RE: **Lot 7 Block 7 SAD 227**
Unser Cliffs
7911 Kibo NW
Grading and Drainage Plan
Engineers Stamp Date 3/28/19 (E10D060)

Based upon the information provided in your submittal received 3/28/19, this plan cannot be approved for Grading Permit until the following comments are addressed.

ENGINEER'S SEAL  3/28/19 DAVID SOULE P.E. #14522	7911 KIBO	DRAWN BY: WCUJ
	GRADING AND DRAINAGE PLAN	DATE: 3-28-19
 1606 CENTRAL AVENUE SE SUITE 201 ALBUQUERQUE, NM 87106 (505) 872-0998		2109027-LAYOUT-3-28-19
		SHEET #
		JOB # 2109027

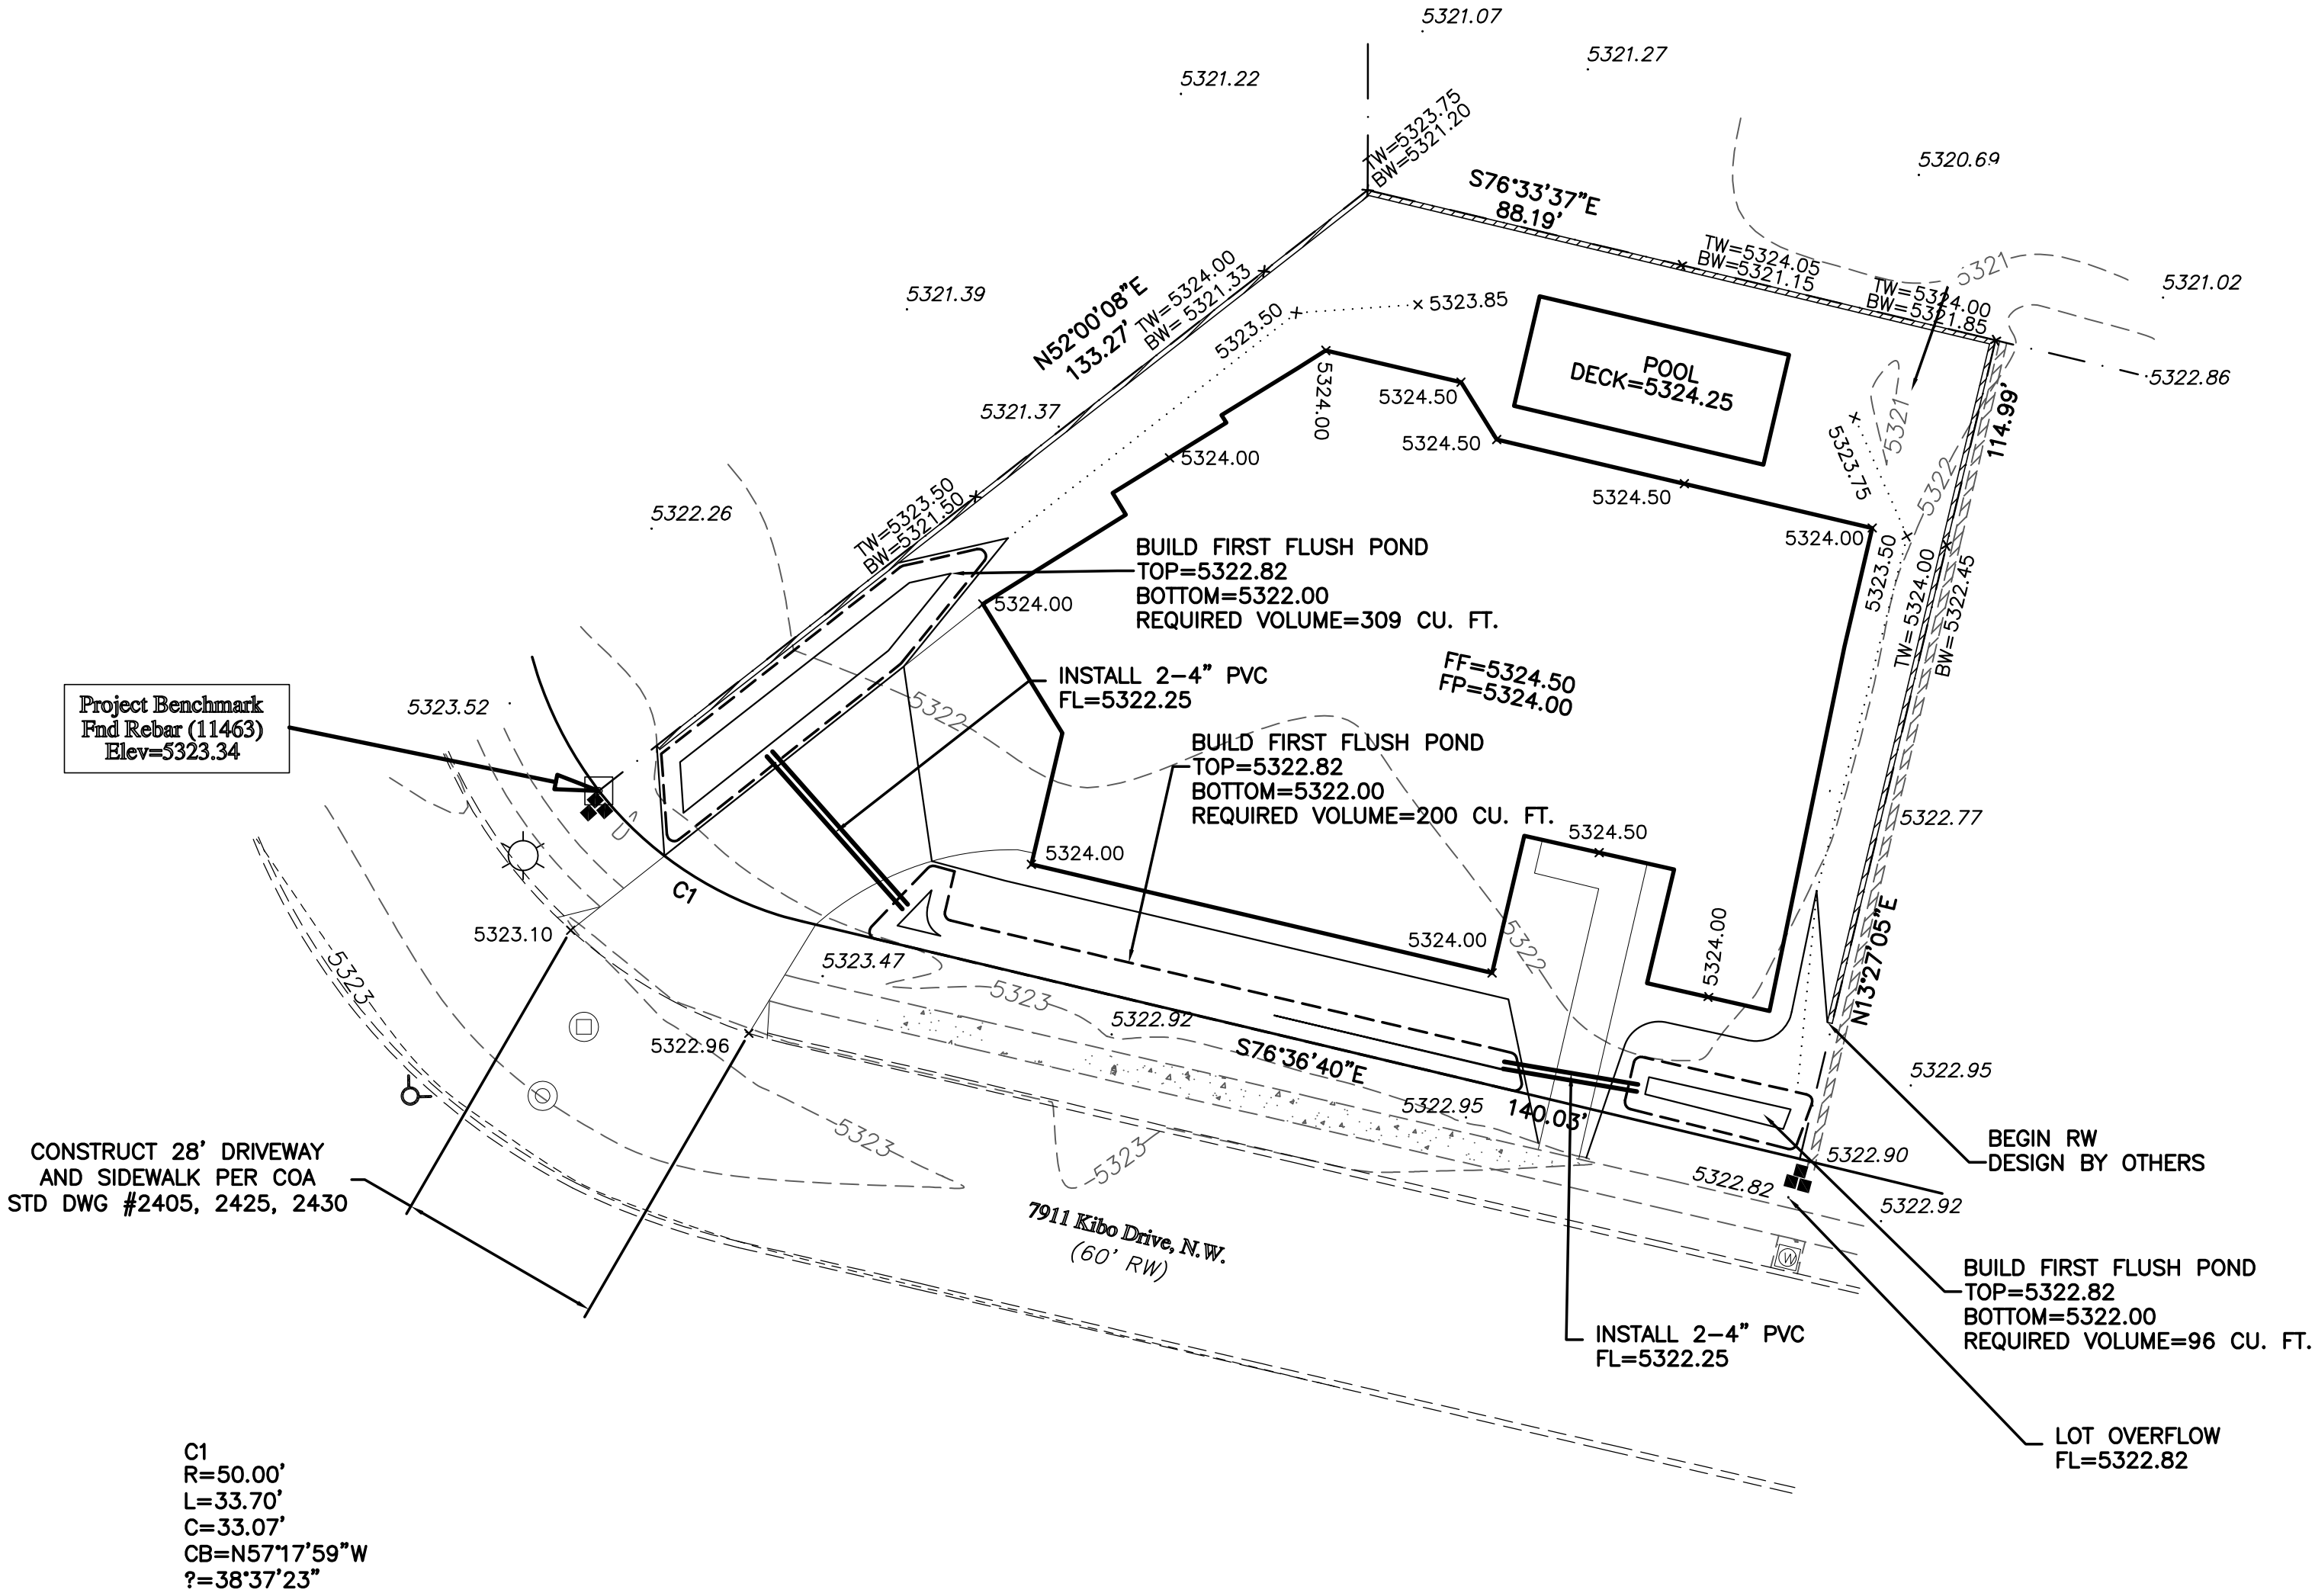
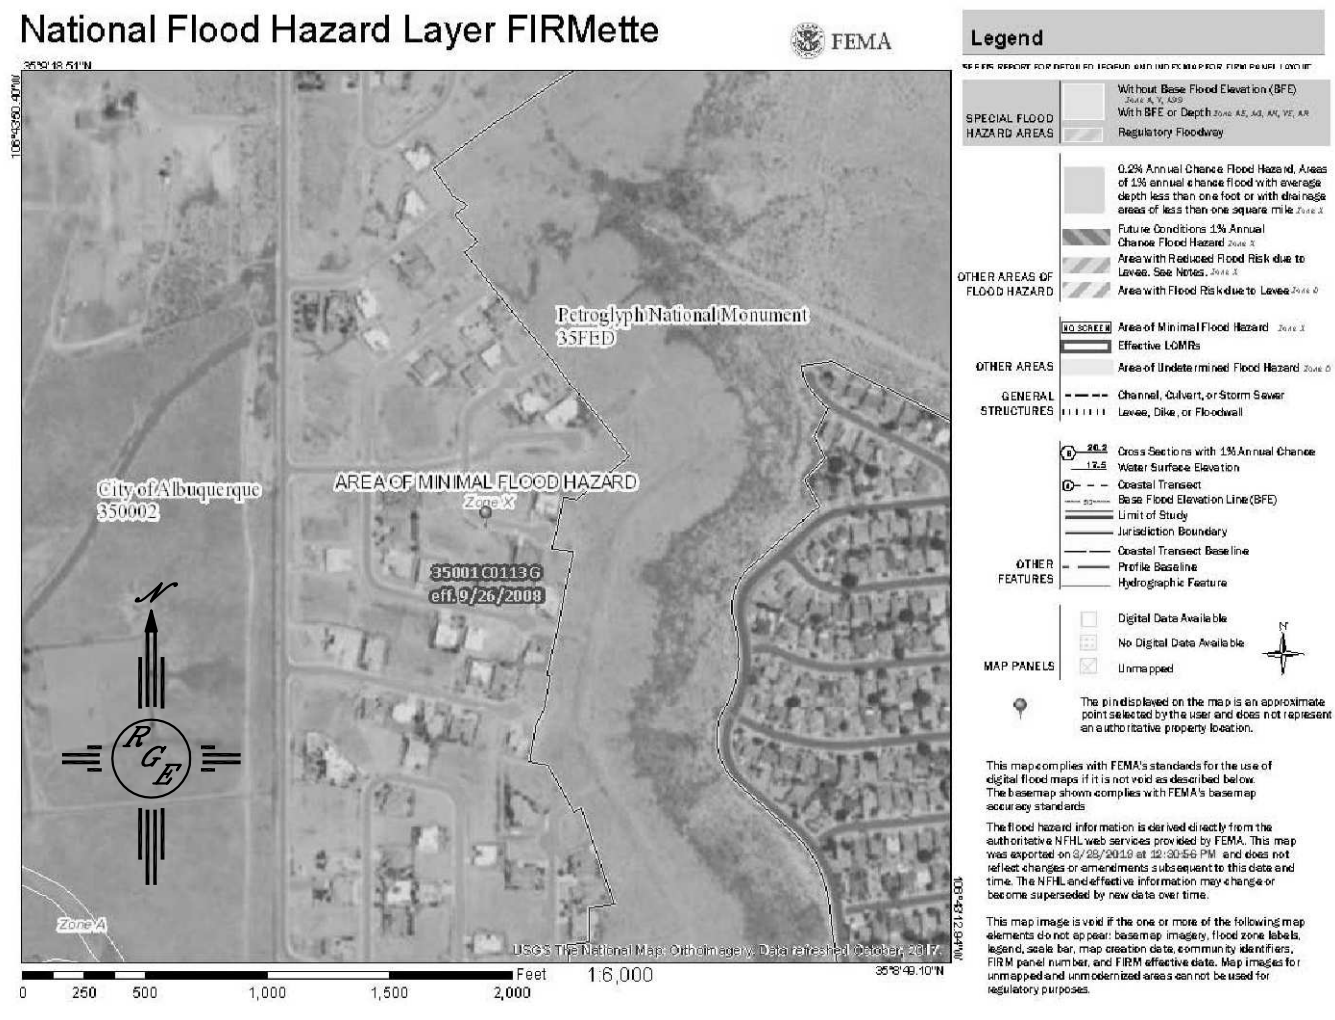
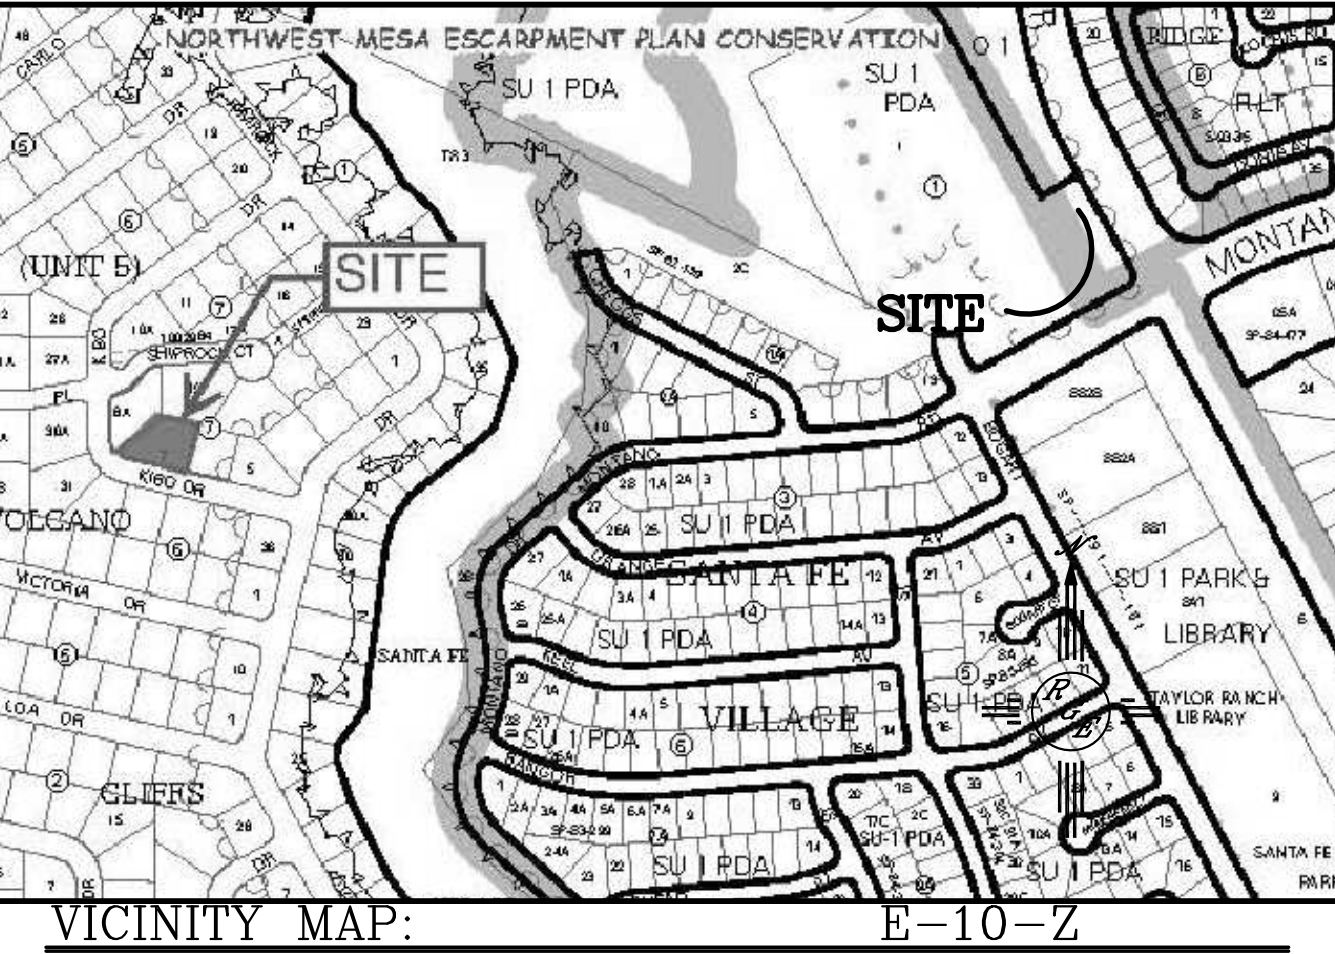
- Provide a detention pond for the site. The percentage required is 34%, the amount of D provided is 58%, the pond must contain the difference which is 24%.
